Re: Meineke
5901 Carmel Drive NE
Traffic Circulation Layout
Architect's Stamp 09-22-2020 (C18-D049)

Based upon the information provided in your submittal received 09-30-2020, the above referenced plan cannot be approved for Building Permit until the following comments are addressed:

C3 BIKE RACK ELEVATION
1/2\"/>

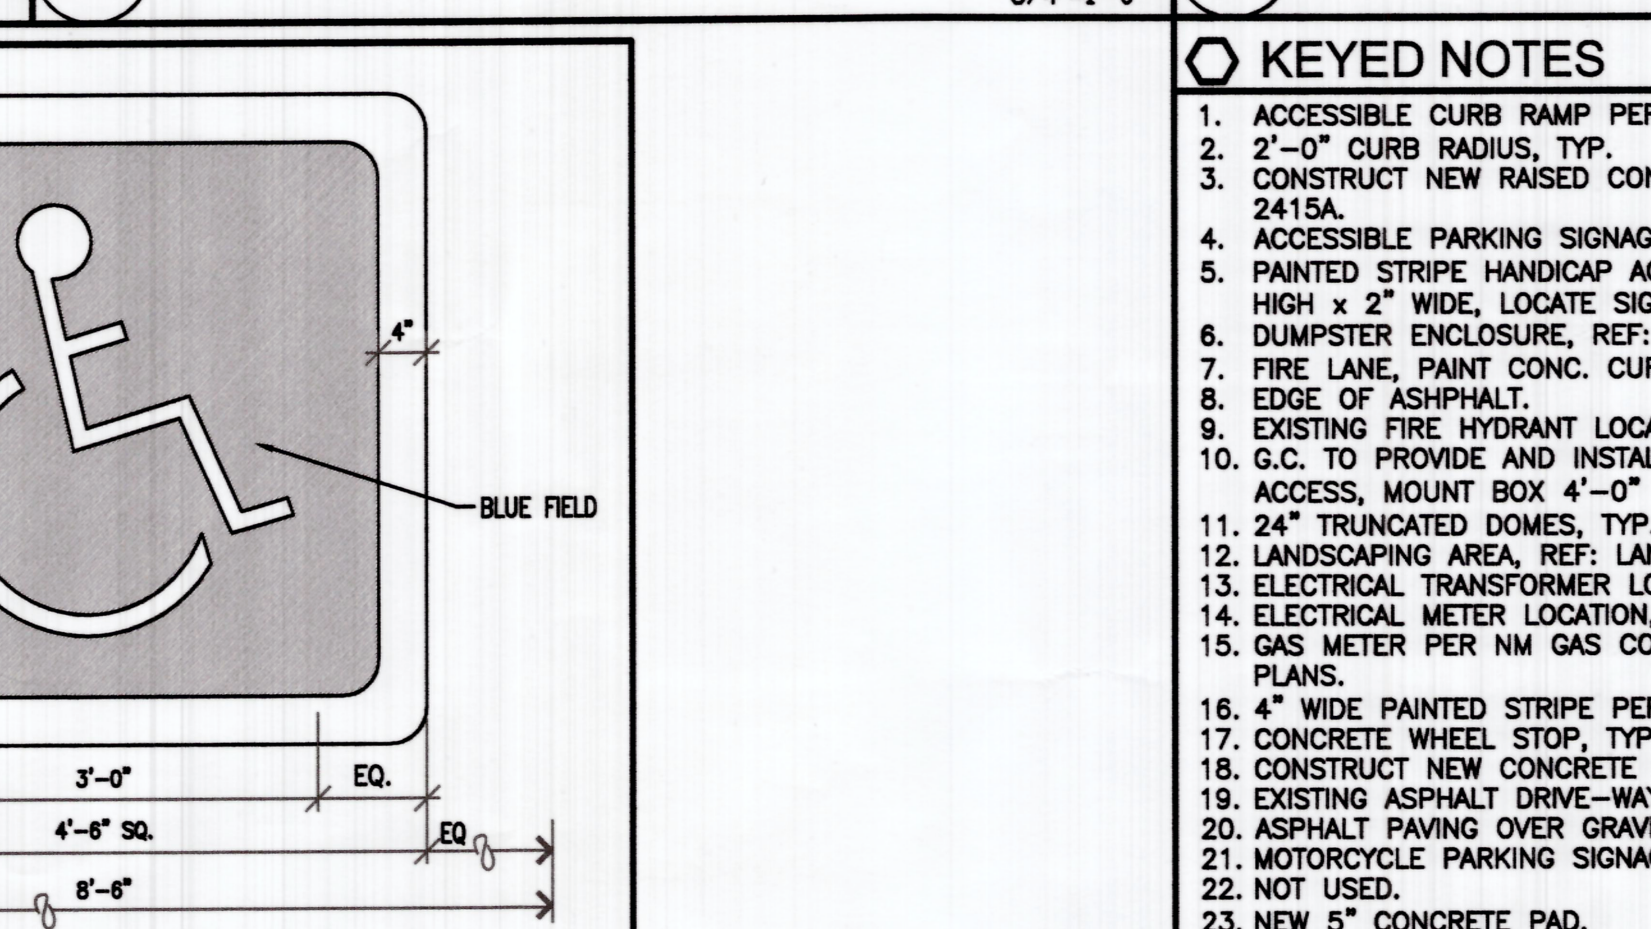
- 7. Bicycle racks shall be sturdy and anchored to a concrete pad.
- 8. A 1-foot clear zone around the bicycle parking stall shall be provided.
- 9. Bicycle parking spaces shall be at least 6 feet long and 2 feet wide.

SHEET NUMBER
AS-1.0

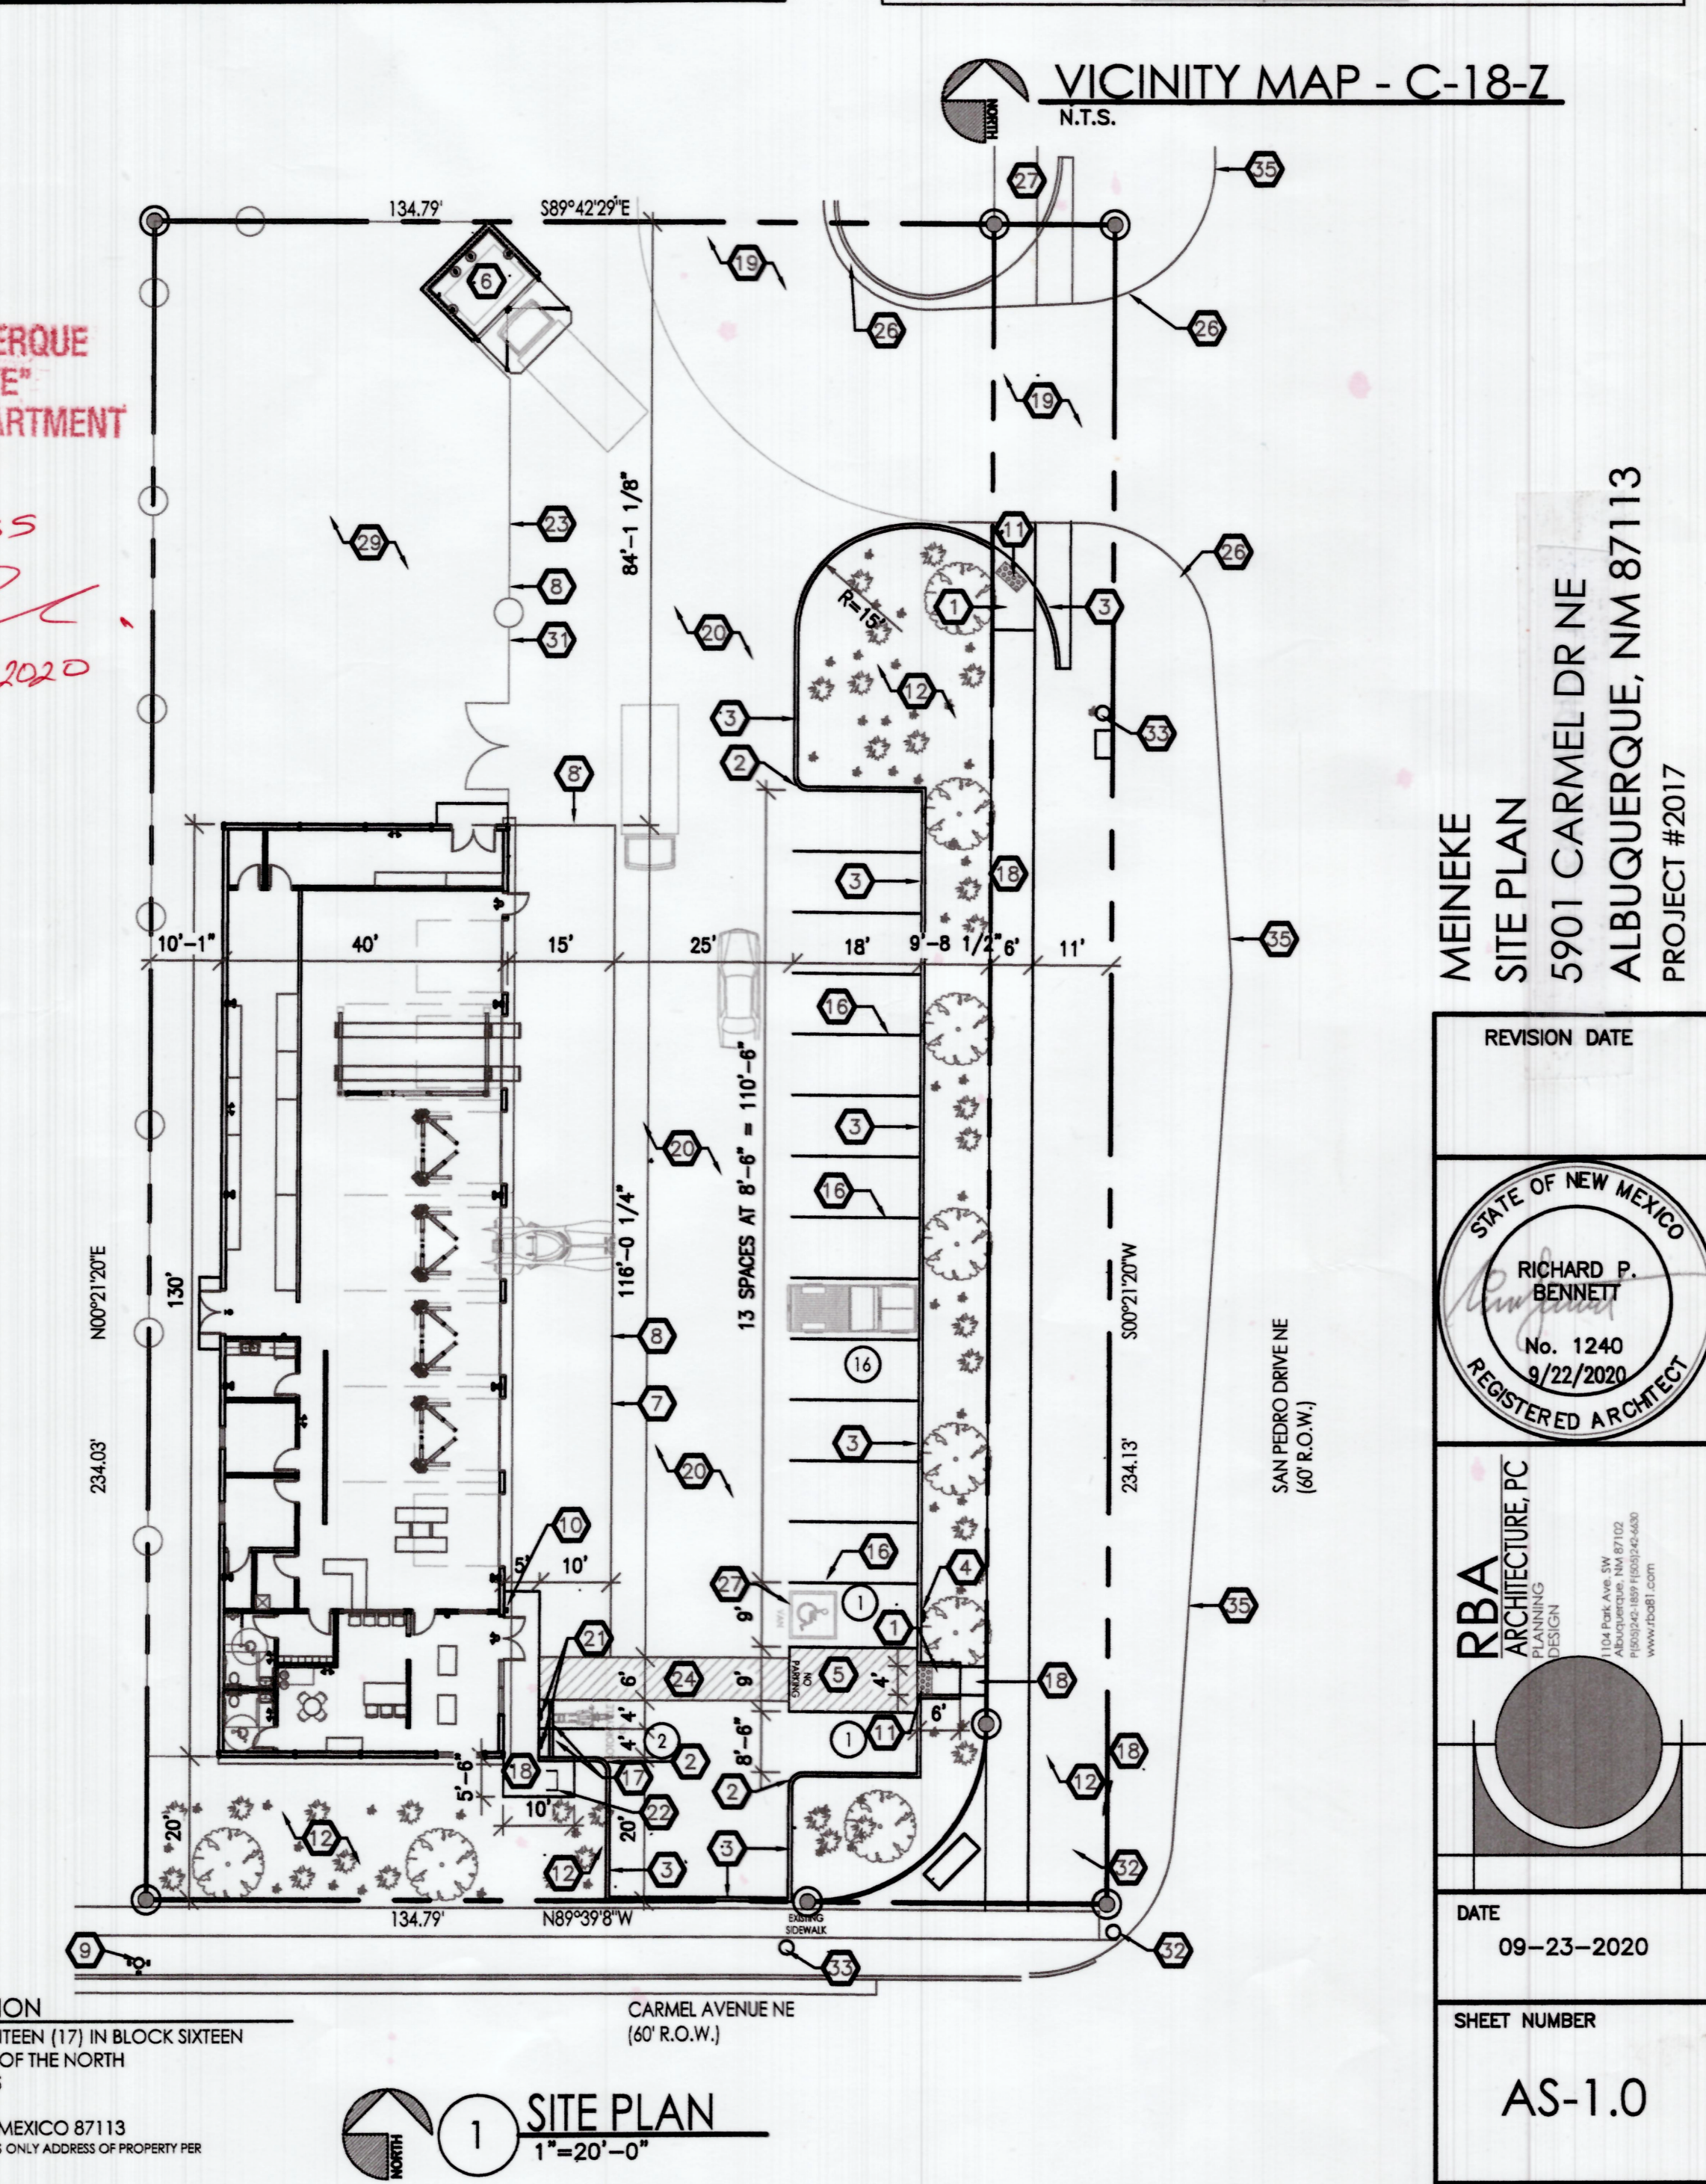
1. The listed number of parking spaces required by the zoning code as well as the proposed number of parking spaces including bicycle and motorcycle parking. All proposed required calculations need to be discussed/coordinated with Zoning.
2. Identify the medians, curb cuts, and street widths on San Pedro Drive and Carmel Ave.
3. Maximum access width for arterial, collector, and local streets are as follows:

4. ADA curb ramps must be updated to current standards and have truncated domes installed off San Pedro corner and driveways.
5. Motorcycle parking spaces: Label pavement MC.
6. All bicycle racks shall be designed according to the following guidelines(**If applicable on all bike notes**):
 - a. The rack shall be a minimum 30 inches tall and 18 inches wide.
 - b. The bicycle frame shall be supported horizontally at two or more places. Comb/toaster racks are not allowed.

- 10. **Show all drive aisle widths and radii. Some dimensions are not shown.**
- 11. Per the IDO, a 6 ft. wide **(not 4 ft wide)** ADA accessible pedestrian pathway is required from the public sidewalk to the building entrances. .

- 12. Per DPM, **a 6 ft. wide ADA accessible pedestrian pathway** is required from the ADA parking stall access aisles to the **building entrances**. Please clearly show this pathway and provide details.

- 13. All existing/proposed sidewalks along Carmel and San Pedro will need the widths provided on site plan.
- 14. Please provide a sight distance exhibit

- 15. Show the clear sight triangle and add the following note to the plan:
"Landscaping and signage will not interfere with clear sight requirements. Therefore, signs, walls, trees, and shrubbery between 3 and 8 feet tall (as measured from the gutter pan) will not be acceptable in the clear sight triangle.

- 18. Keyed Note 35: Will require a work order as stated and you will need to provide the work order number and DRB number.
- 19. Keyed Notes (Need to address-see site plan): 4,5,6,16,21 &22.

- 20. Keyed Note 7: A sign face detail will need to be provided and review where you have located it.
- 21. It appears the San Pedro frontage will require some ROW dedication. Please contact Jeanne Wolfenbarger for any further discussion/in put to this concern and the Keyed Note 35 status.
